From: Laura Gibbons [REDACTED]
Sent: 01 February 2022 15:19
To: Planning.Responses [REDACTED]
Cc: Simon Davis [REDACTED]
Subject: RE: Planning Consultation on: Y/185/21/DOC

Engineers Comments Regarding Condition 9

Application No: Y/185/21/DOC

Site Address: Land East of Drove Lane Yapton BN18 0EB

DRAINAGE CONSTRUCTION DETAILS (SHEET 1 OF 2)

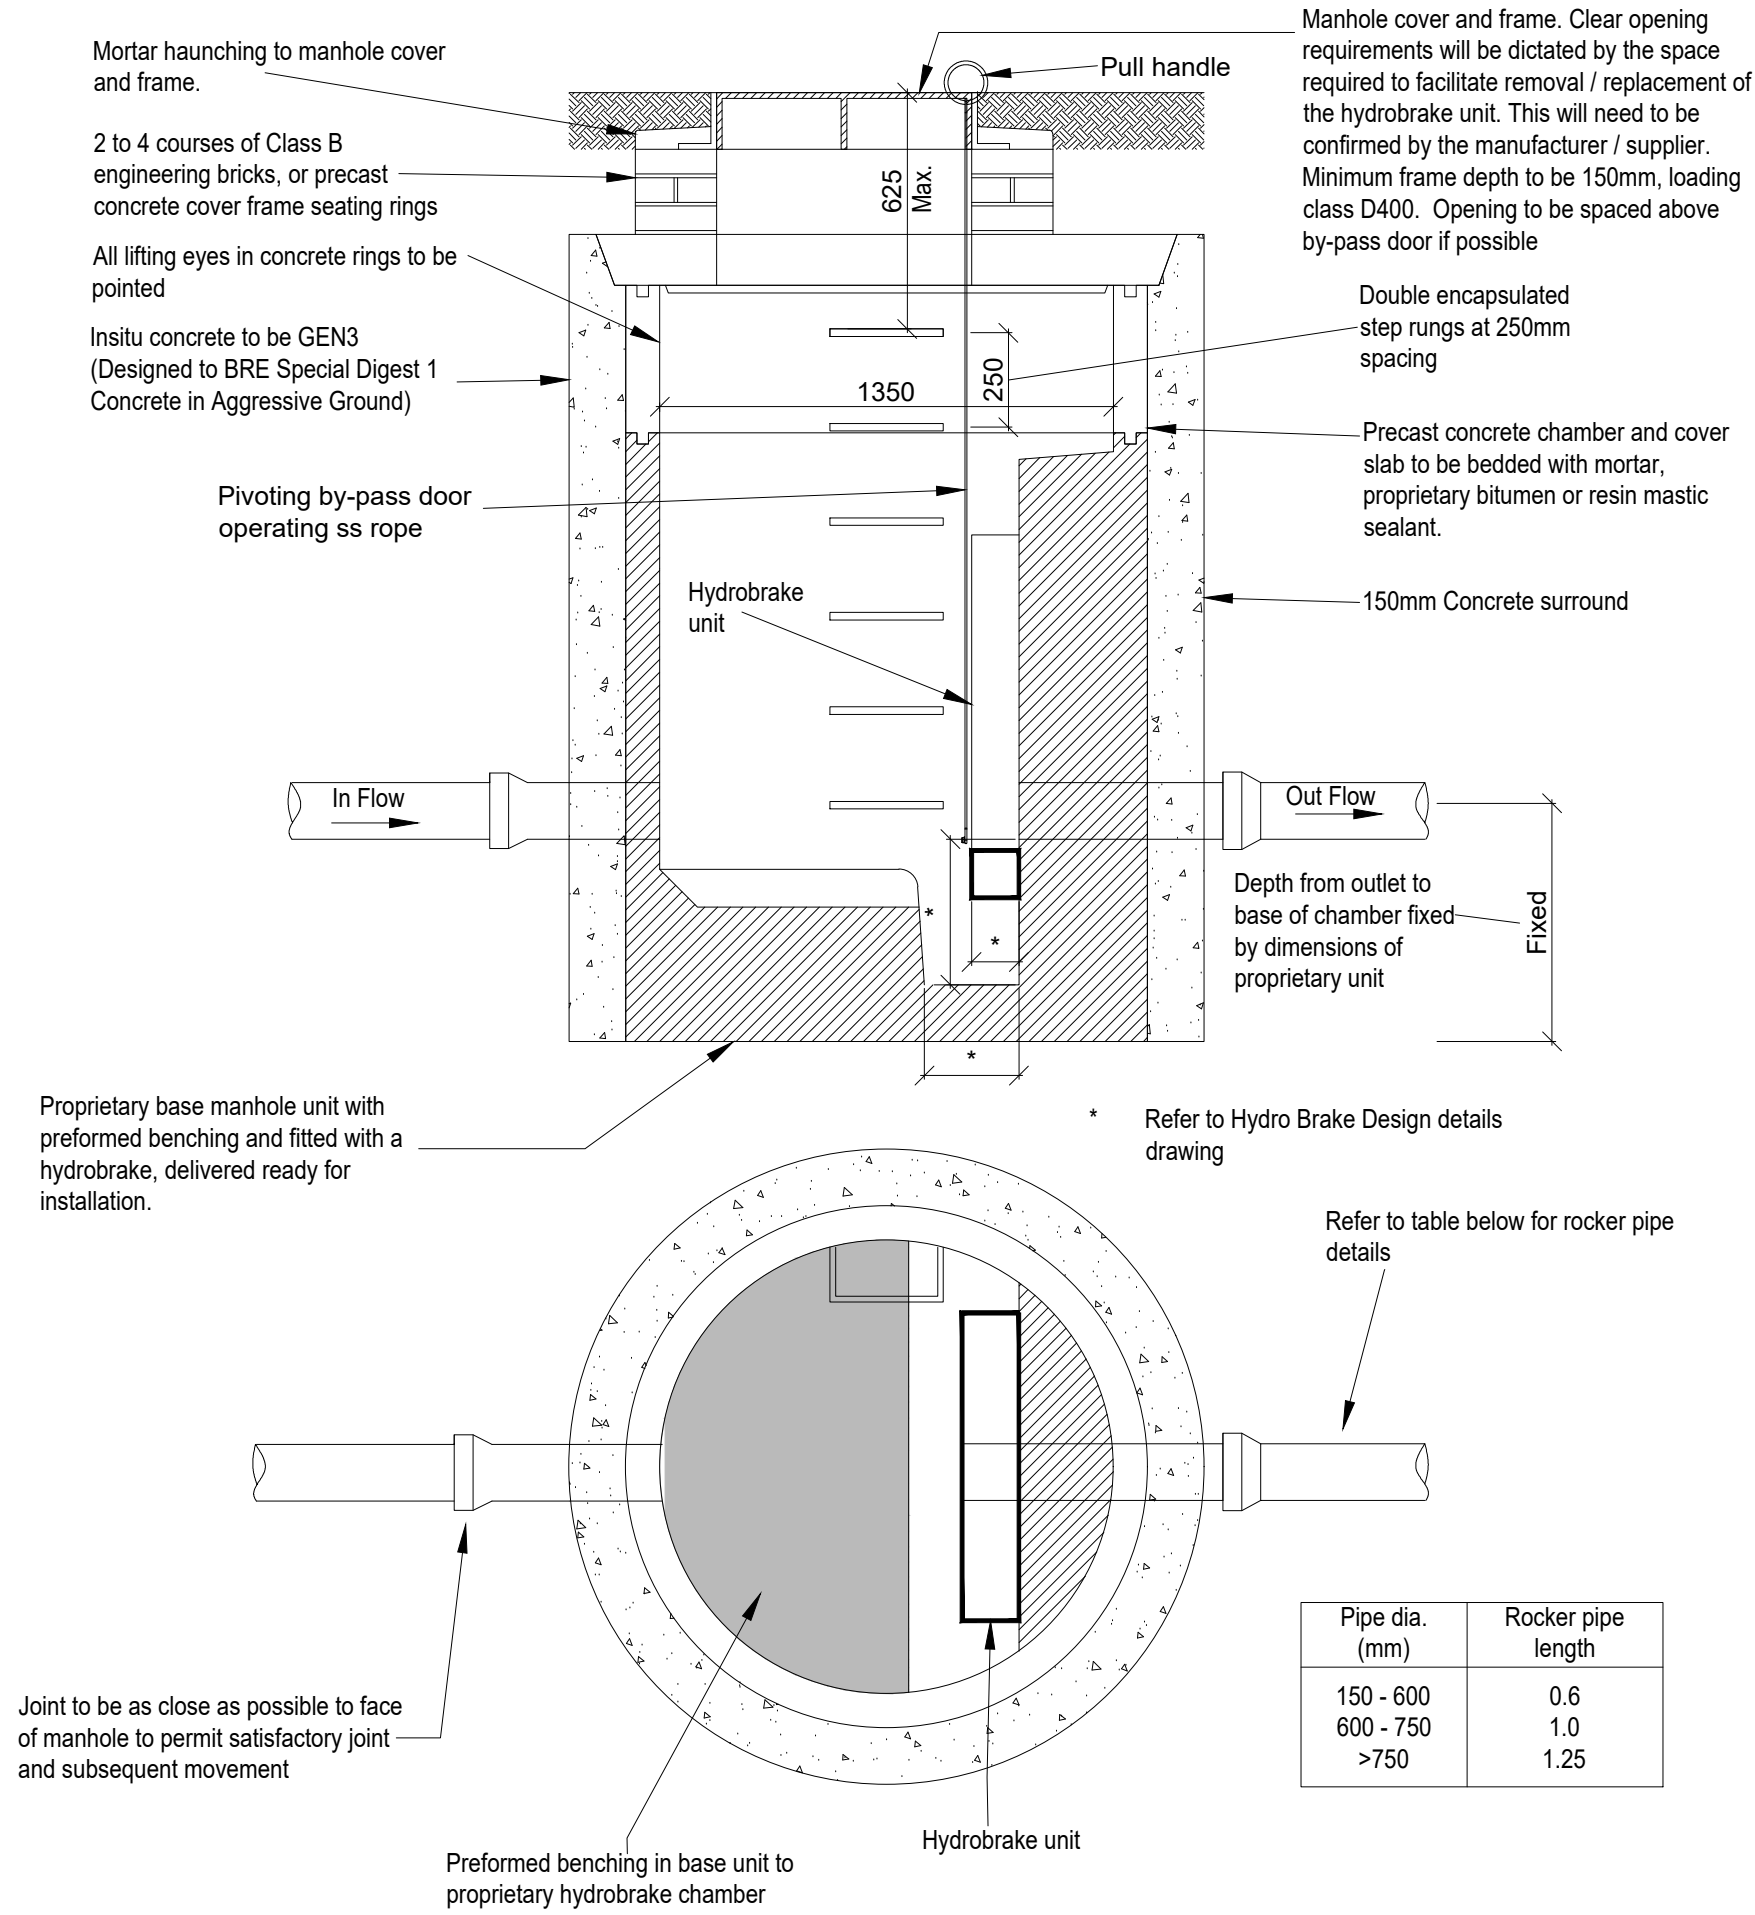
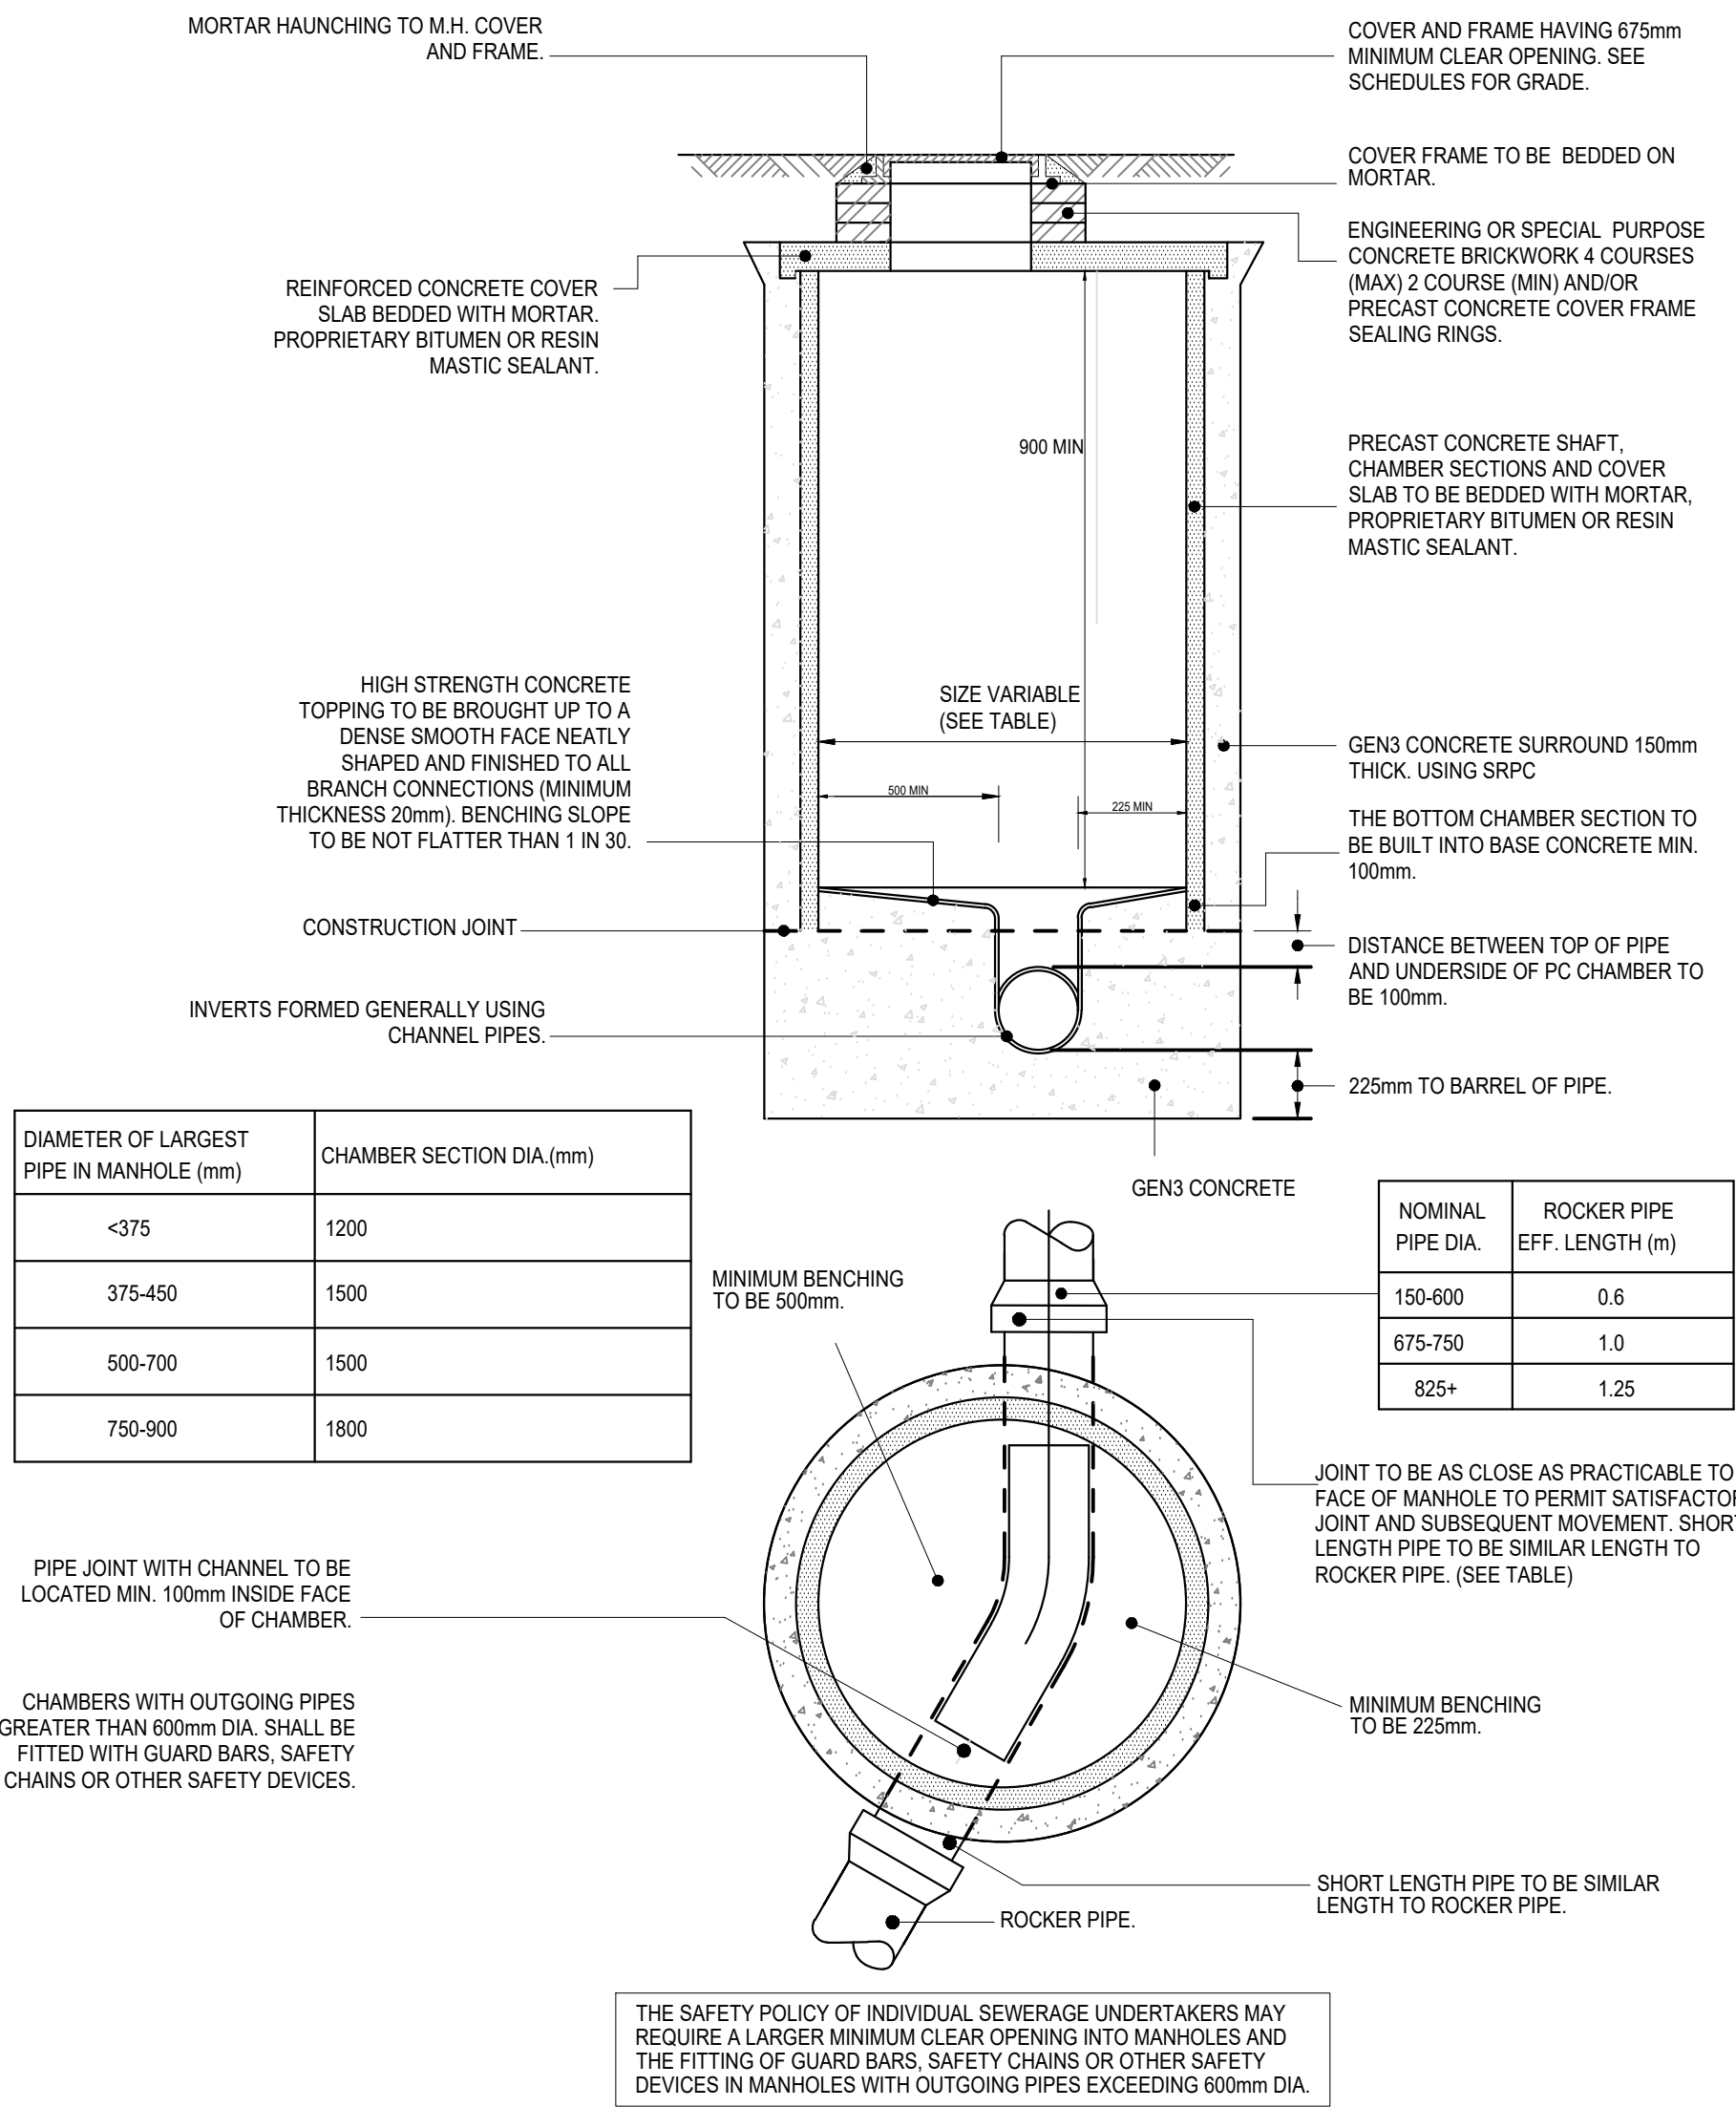
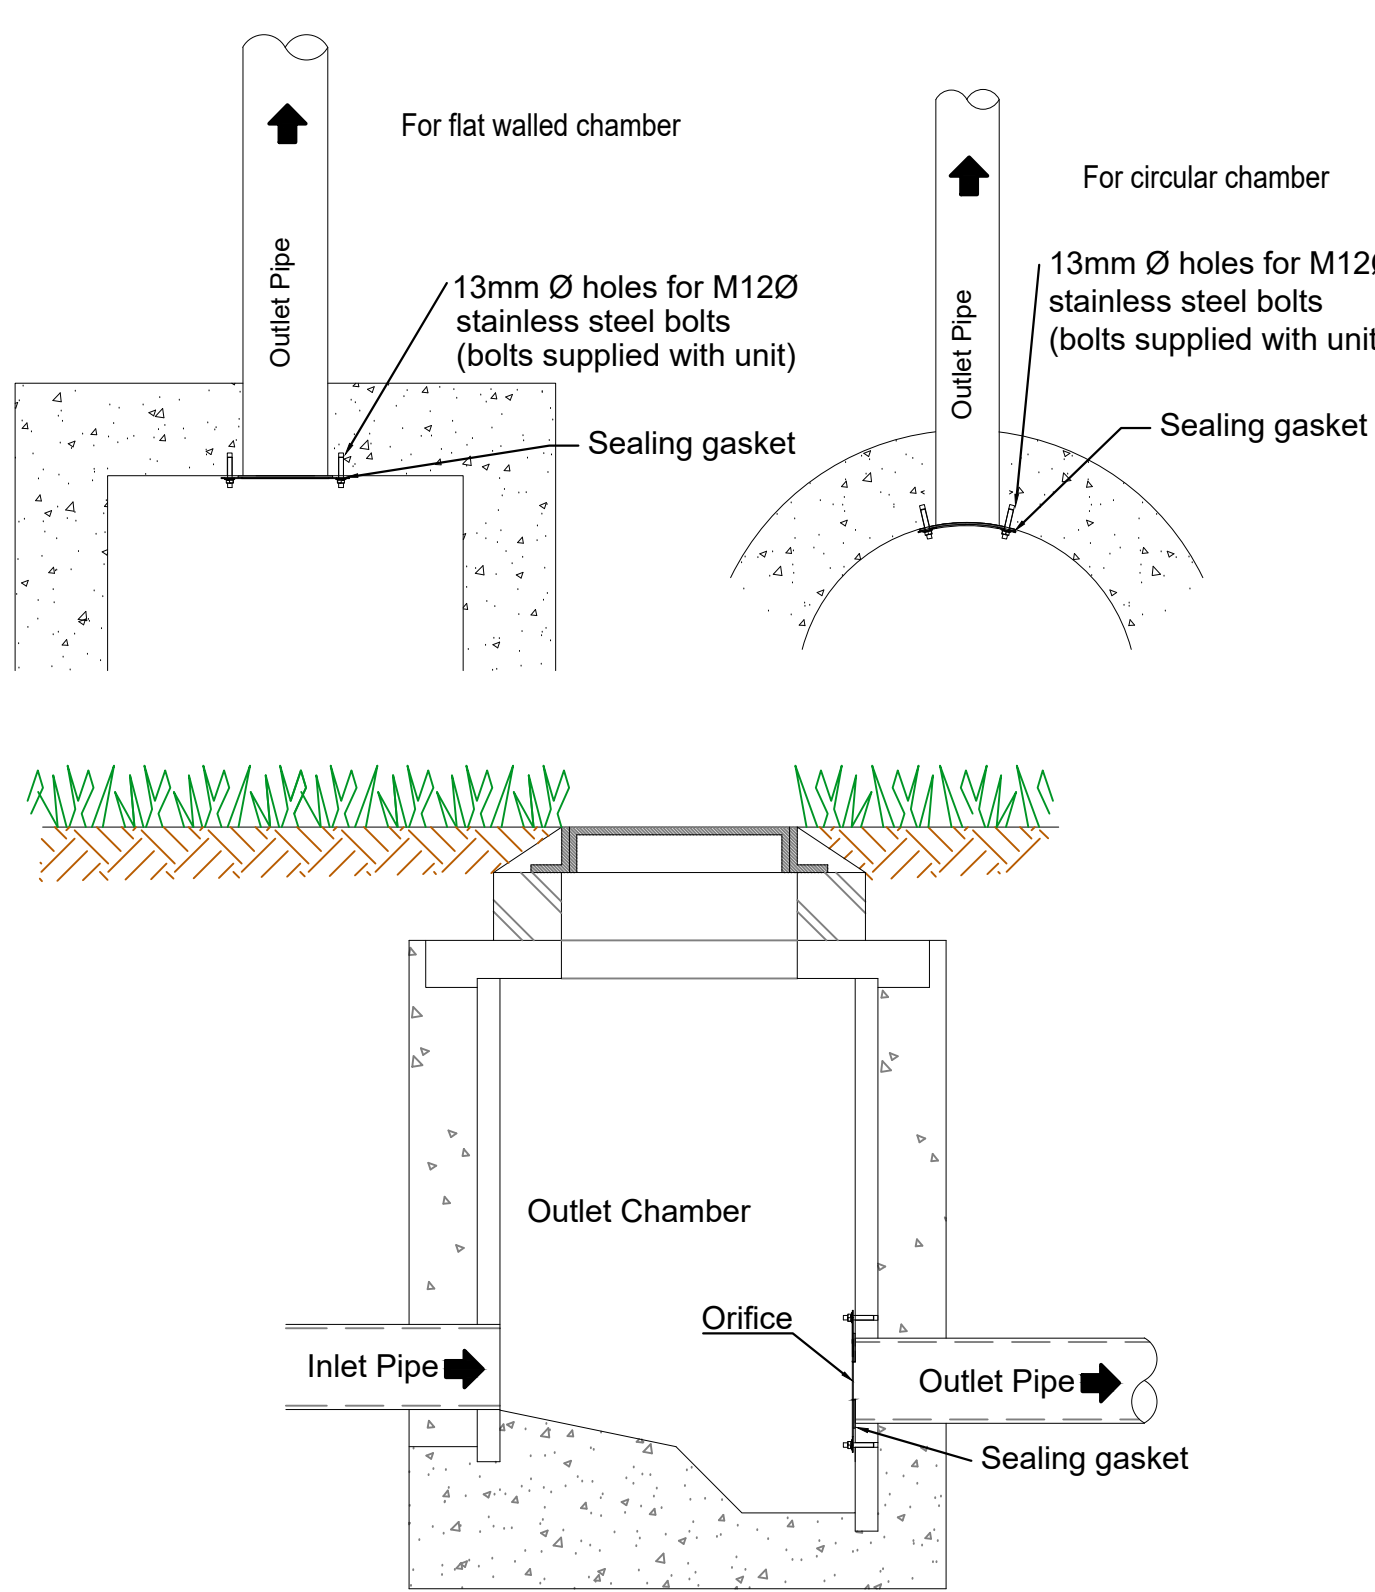
Please include a section on hydrobrake maintenance, this should include the regular greasing and moving of the bypass door.
